Addendum Response to Submissions – Section 4.55(1A) Modification – Approved signage at the Overseas Passenger Terminal (Tenancy 5) at Circular Quay West in The Rocks (SSD 7683 MOD 1)

This addendum Response to Submissions (RtS) has been prepared on behalf of Jimmy's on the Mall Pty Ltd (the Applicant) to address the City of Sydney Council's (Council) submission on the RtS that was lodged with the Department on 17 January 2019 for the above Section 4.55(1A) modification application.

## Level 1 Floorplan

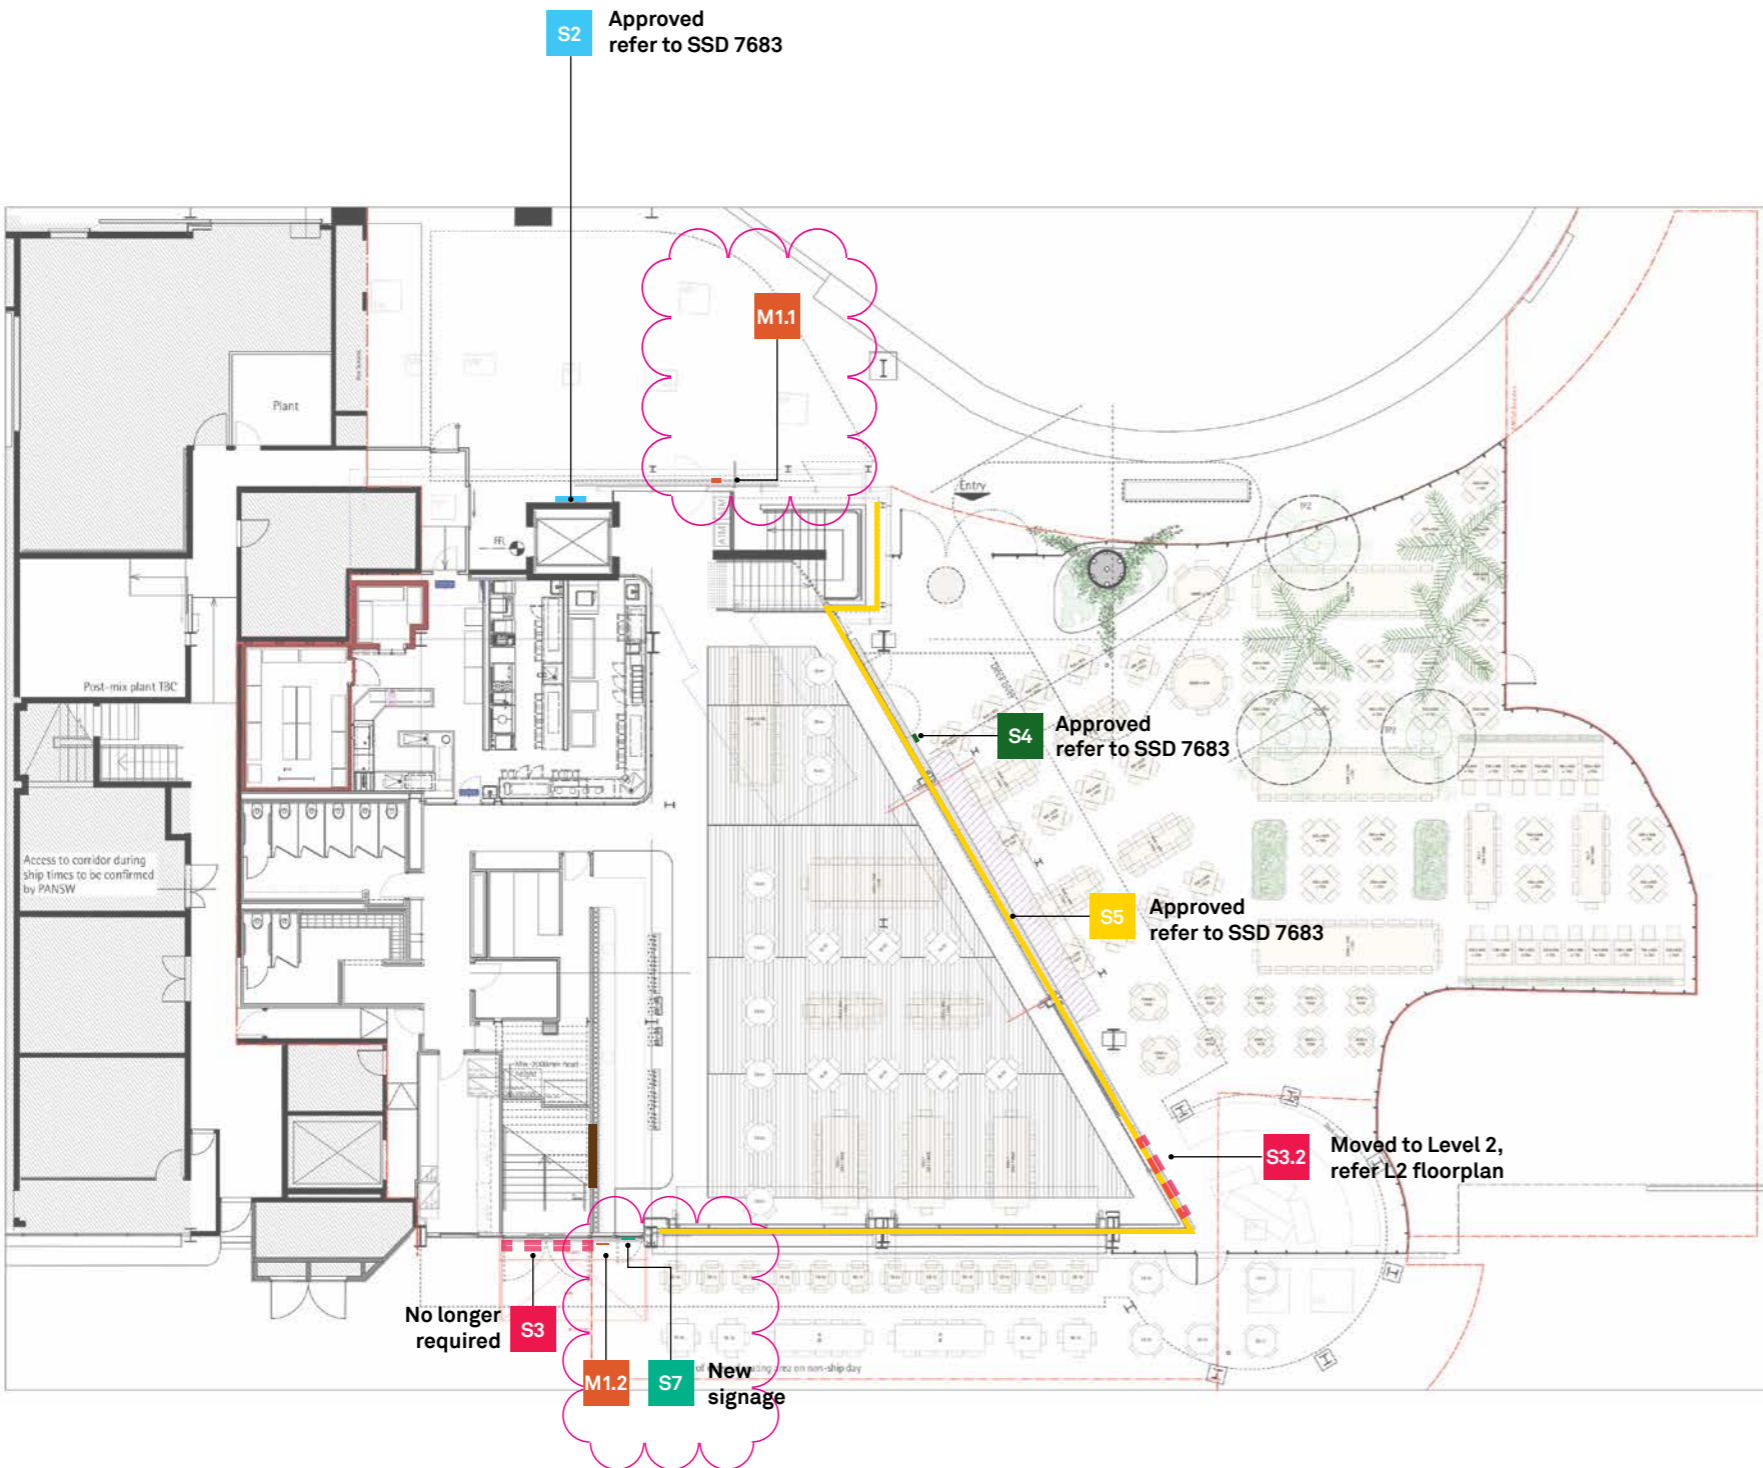
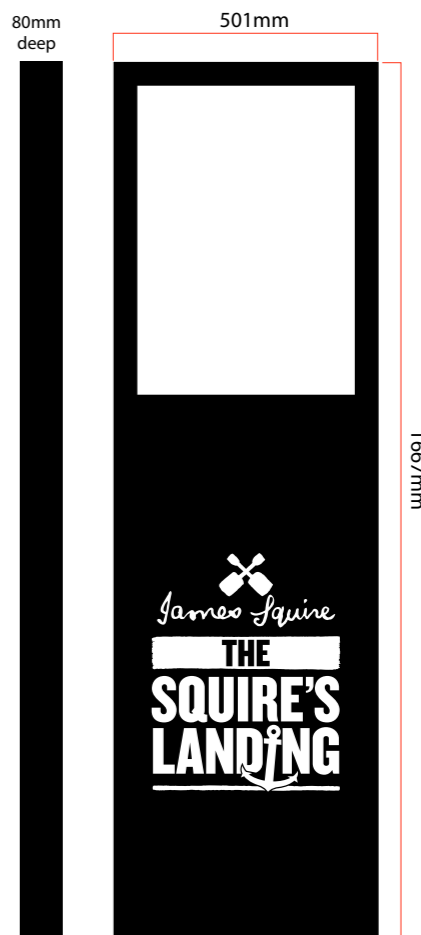
We note that the submission received from Council dated 31 January 2019 objects to the approval of more than two menu stands. To address Council's concerns, the Applicant has further reduced the number of menu stands at the site from three to two. The two menu stands will be located at the two main entry points to the venue. Revised architectural plans are submitted as part of this addendum RtS. We trust that this results in Council withdrawing its objection to the modification.
